**One Earth Solar Farm**

**PINS Application ref. EN010159**

## Appendix A - Applicant's response to Section 51 and Section 55

Drawing Title:
Figure 7.4: Existing Flood Defences

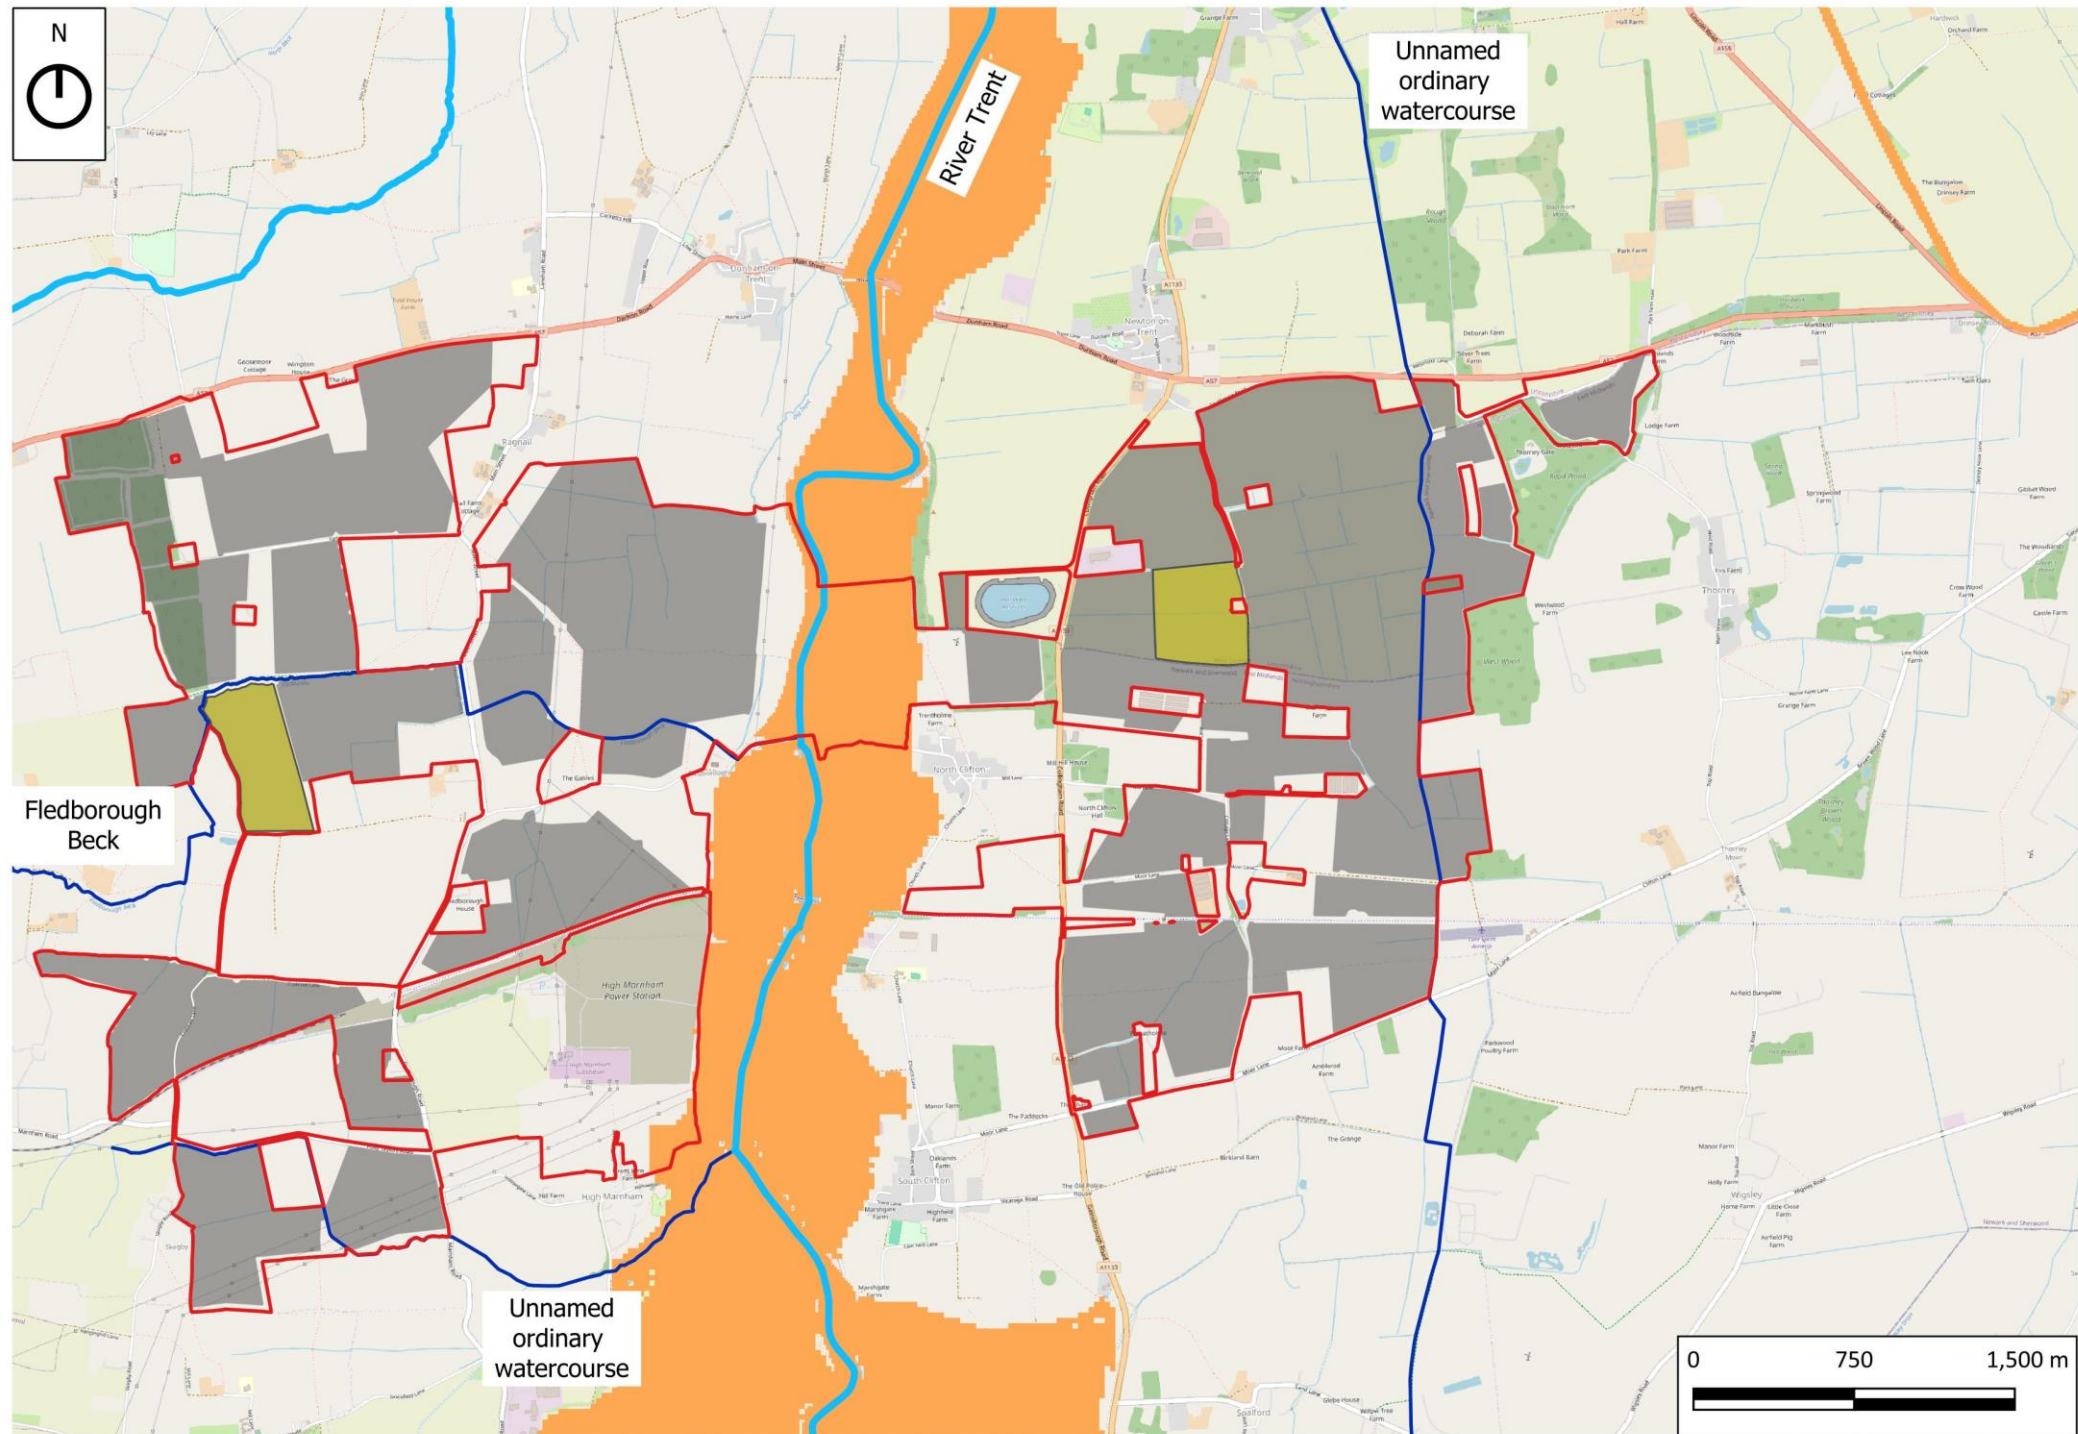
Flood Risk Assessment (FRA) and Outline Drainage Strategy (Doc 6.21)	A figure in the FRA distinguishing which areas of the proposed development's order limits are within Flood Zone 3a and Flood Zone 3b is required. The Environment Agency published new flood and coastal erosion risk data on 28 January 2025 with further data planned for release on 25 March 2025. Once this further data has been released by the Environment Agency, the applicant should provide updated versions of the relevant assessments including the FRA, based upon the updated Environment Agency data.	6.7 Chapter 7 – Hydrology and Hydrogeology, Appendix 7.2: Flood Risk Assessment and Outline Drainage Strategy and Figure 7.1-7.17 has been updated to include the Environment Agency new flood and coastal erosion risk data (as released on 25 March 2025). This modelling has not changed the likely significant effects or the design of the Proposed Development, as previously reported.	The following documents have been updated and are provided with this submission: <ul style="list-style-type: none"> <li>- 6.7 Chapter 7 – Hydrology and Hydrogeology (Ref. APP-036) (Clean and Tracked)</li> <li>- Appendix 7.2: Flood Risk Assessment and Outline Drainage Strategy (Ref. APP-APP-095) (Clean and Tracked)</li> <li>- Figure 7.1-7.17 (Ref. APP-052)</li> </ul>
